**A38 Derby Junctions**  
**TR010022**  
**8.98 Statements of Common Ground**  
**Position Statement**

**Statements of Common Ground Position Statement**

<b>Regulation Number</b>	Rule 8(1)(k)
<b>Planning Inspectorate Scheme Reference</b>	TR010022
<b>Document Reference</b>	TR010022/APP/8.98
<b>Author</b>	A38 Derby Junctions Project Team and Highways England

The
 ADL PROPOSED ACCESS AND EGRESS
 OFF HIGHWAYS ENGLAND SLIP LANE

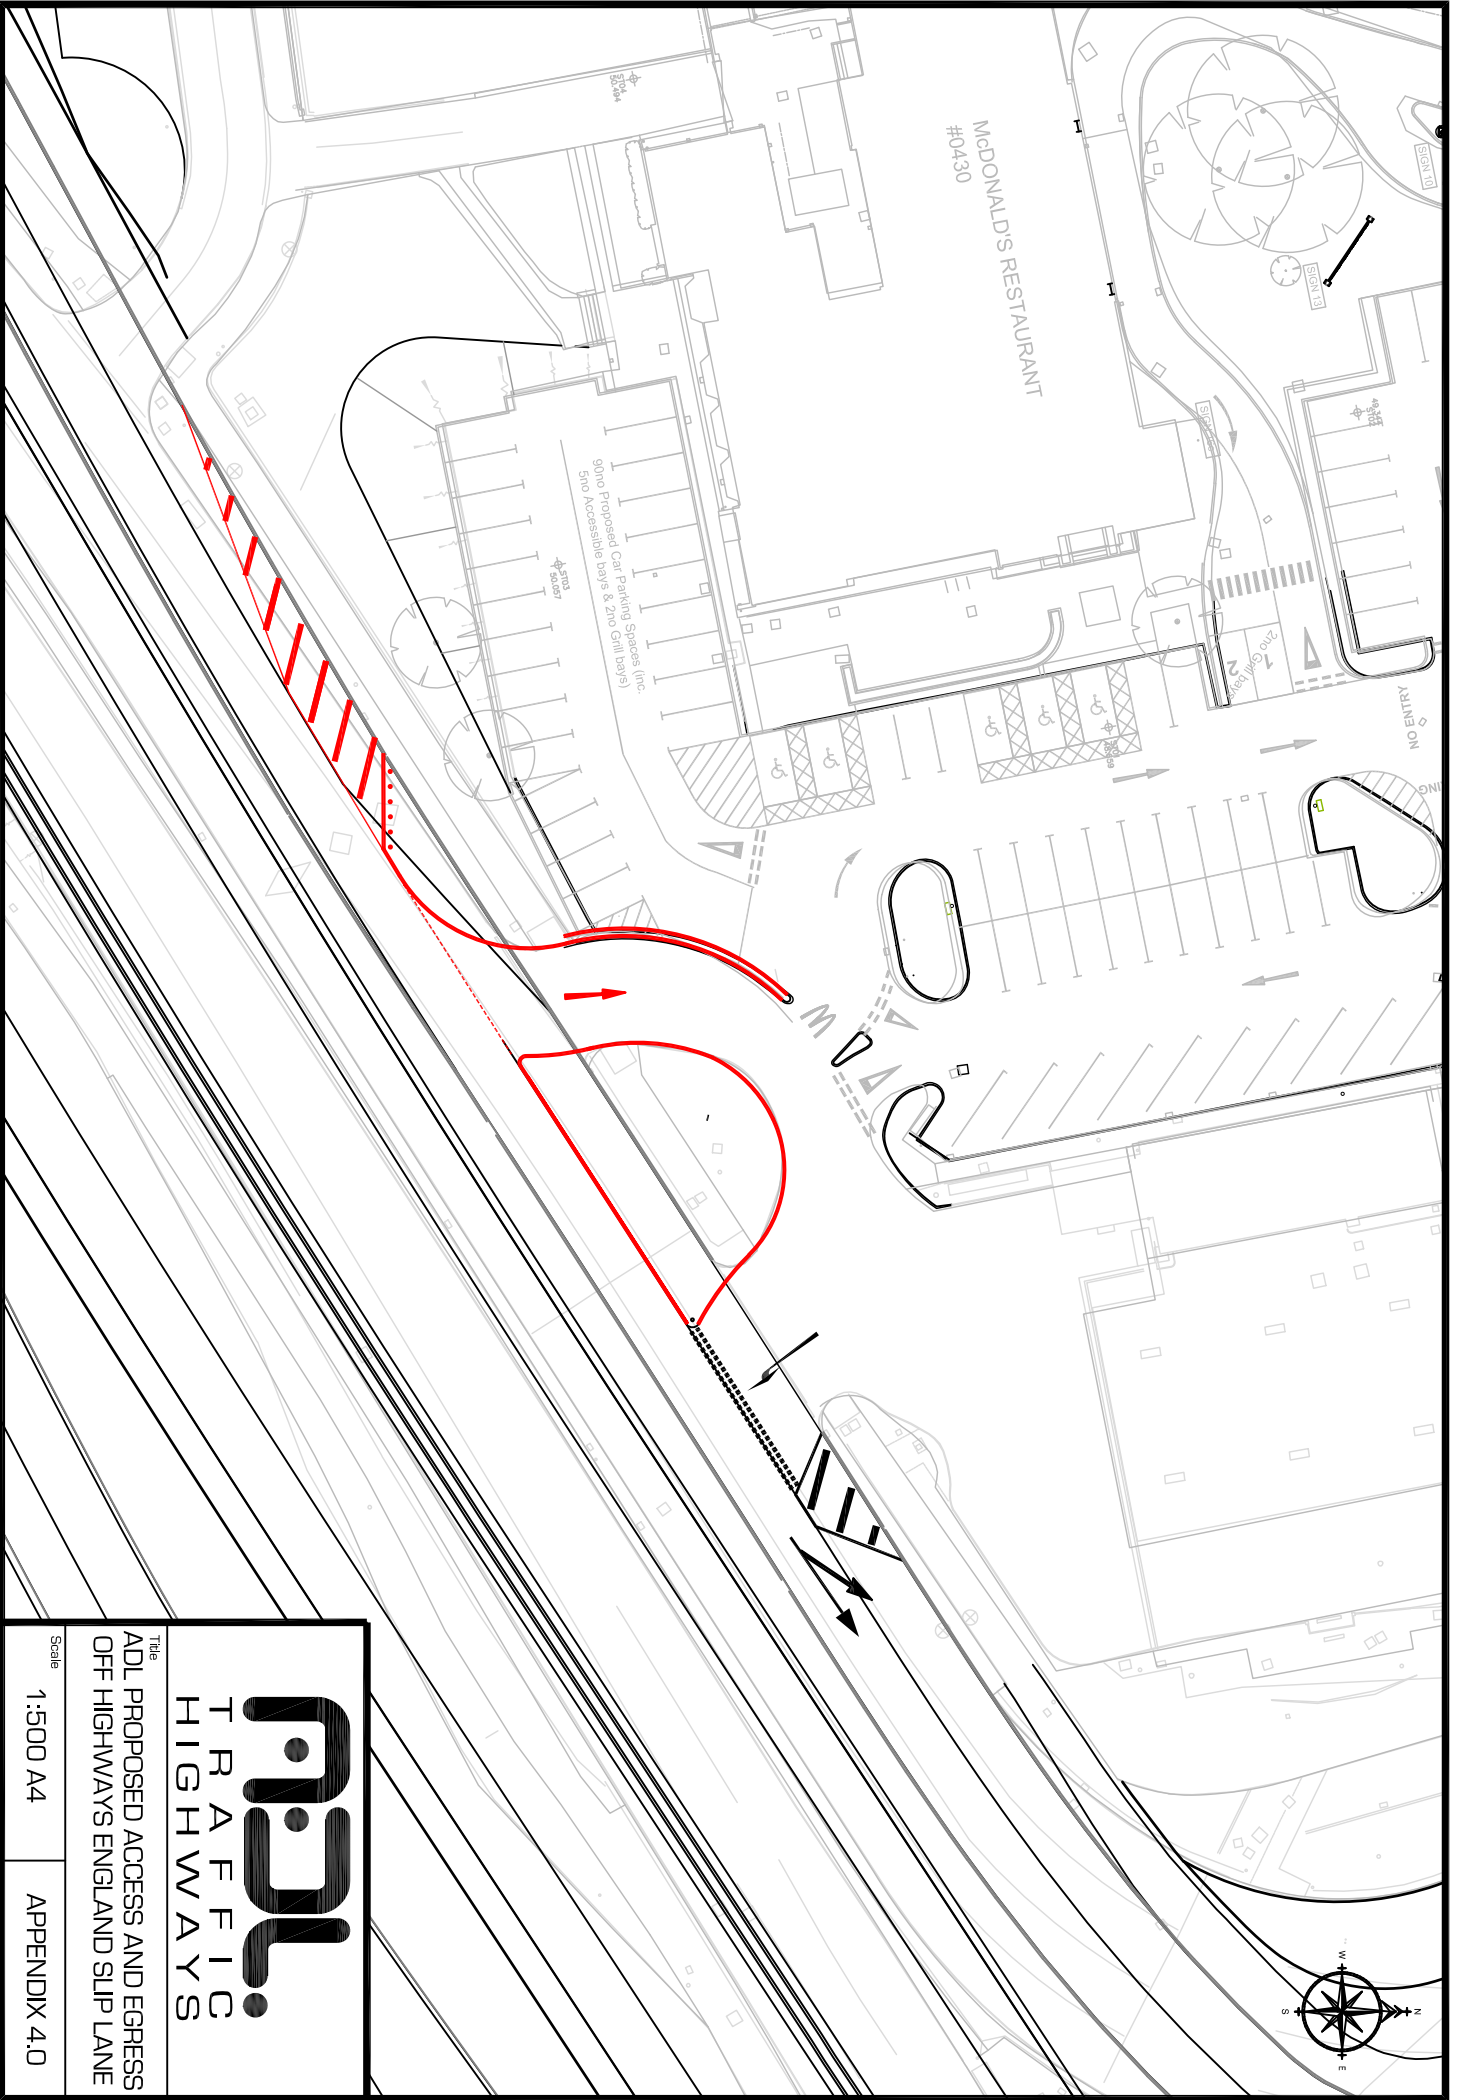
<p>Euro Garages has ongoing concerns over the geometric standards applied to the proposed access/egress with the A52.</p>	<p>The proposed arrangements are similar to the existing layout and will be usable for all future traffic. The detailed design stage will be used to refine the design in consultation with DCiC, EGL and McDonald's and the final design will be subject to a Stage 2 Road Safety Audit so safety of operation will be assured.</p> <p><b>ACTION – To be addressed through further joint meeting with Euro Garages and McDonald's during examination phase.</b></p>
<b>McDonald's</b>

Status	Comment	Applicant's Response and Action
	<p>McDonald's has ongoing concerns over the geometric standards applied to the proposed access/egress with the A52.</p>	<p>The proposed arrangements are similar to the existing layout and will be usable for all future traffic. The detailed design stage will be used to refine the design in consultation with DCiC, EGL and McDonald's and the final design will be subject to a Stage 2 Road Safety Audit so safety of operation will be assured.</p> <p><b>ACTION – To be addressed through further joint meeting with McDonalds and Euro Garages during examination phase.</b></p>
